Ribble Valley Borough Council  
Housing & Development Control

Application no: **3/2021/0710**

Address: **Lodematic Ltd Primrose Works Primrose Road Clitheroe BB7 1BS**

Proposal: **Variation of Condition 2 (Plans) of planning permission 3/2019/0954. Proposed change of Apartment 3 from a two-bedroom apartment to a three-bedroom apartment. Reconfiguration of car parking arrangements.**

PROPOSED CAR PARKING PLAN

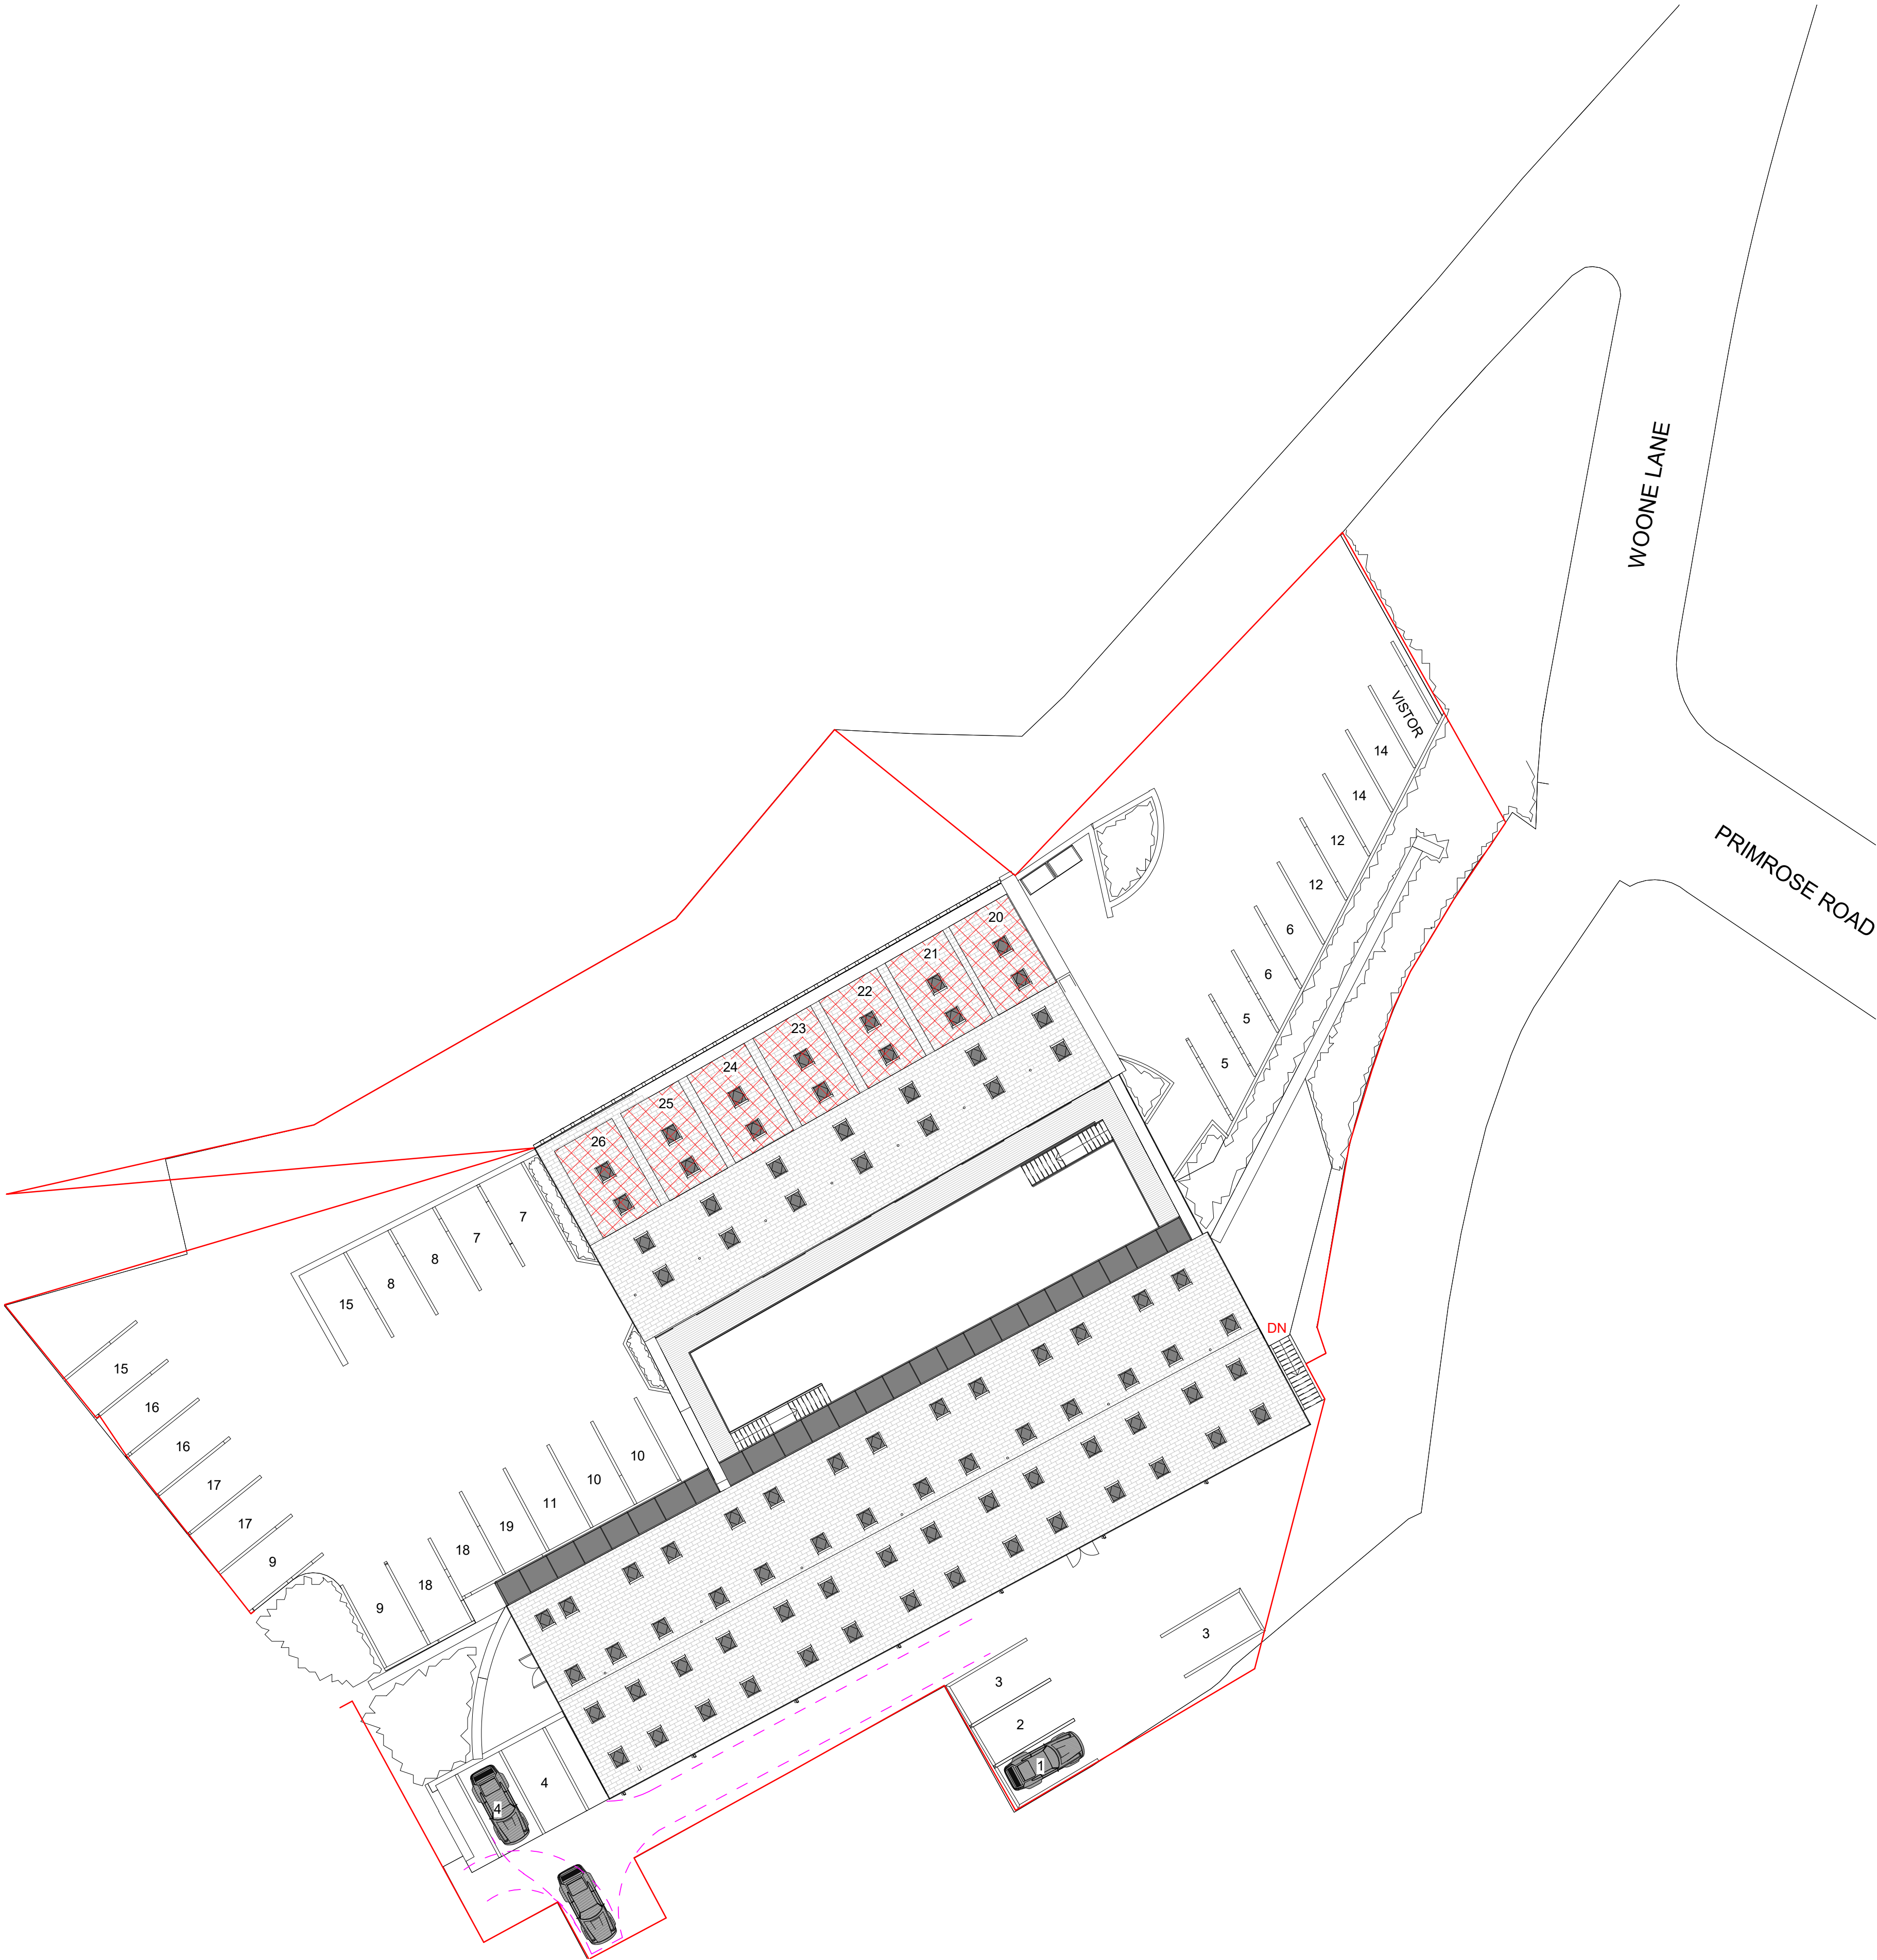
The LHA have reviewed Peter Hitchen drawing number A1.16 titled "Proposed Car Parking Plan" and understands that 2 car parking spaces will be provided for Apartment 3 which will change to a 3-bed apartment following the variation of condition. This complies with the LHAs Joint Lancashire Structure Plan and so have no objection to the variation of condition.

Furthermore the LHA, have further reviewed the drawing and understands that Apartment 13 currently does not have access to a designated parking space on the plan. However, the LHA are aware that there is a visitor space which can be used for Apartment 13 and so the LHA have no further comments to make.
